PLANNING DEPARTMENT – Development Review Services

**Re: La Luz del Oeste, Unit 4 Grading and Drainage Plan
Grading and Drainage Plan
Engineer's Stamp Date 9-2-2014 (File: F11D002A)**

Based upon the information provided in your submittal received 9-3-14, the above referenced Plan is approved for Grading Permit [for the Retaining Wall] with the following conditions/ comments:

**GRADING AND DRAINAGE  
PLAN**

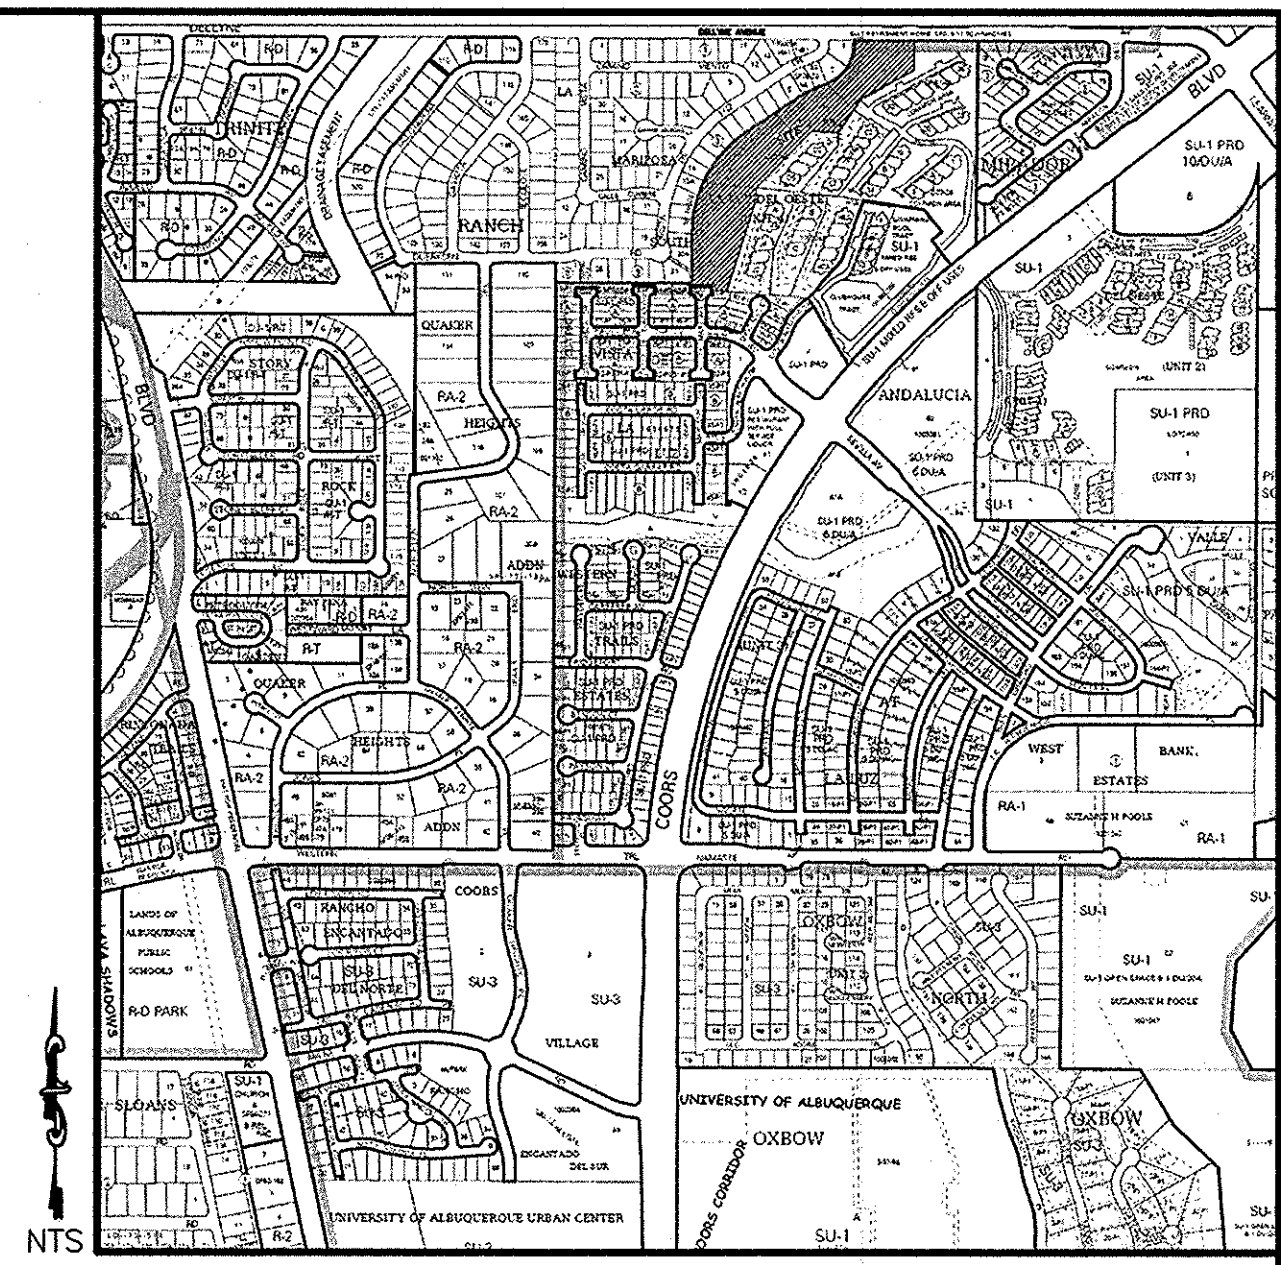
- Ponds in Basin 101 and 106 must maintain a percolation rate of 2.9 min/in. Pond volumes in these basins are considerably smaller than in the previously approved submittal. However, it is noted in the narrative that only the roadway drains to those ponds and a percolation rate of 2.9 min/in is used for the soils. The ponds only seem to be sufficient if the percolation rate is factored in. Therefore, provide percolation test data and note the percolation rate on the As-built Certification Plan.
- The Pad Elevations are higher than the previously approved submittal
- Distance between double retaining walls changed to 10' (not shown on section detail)
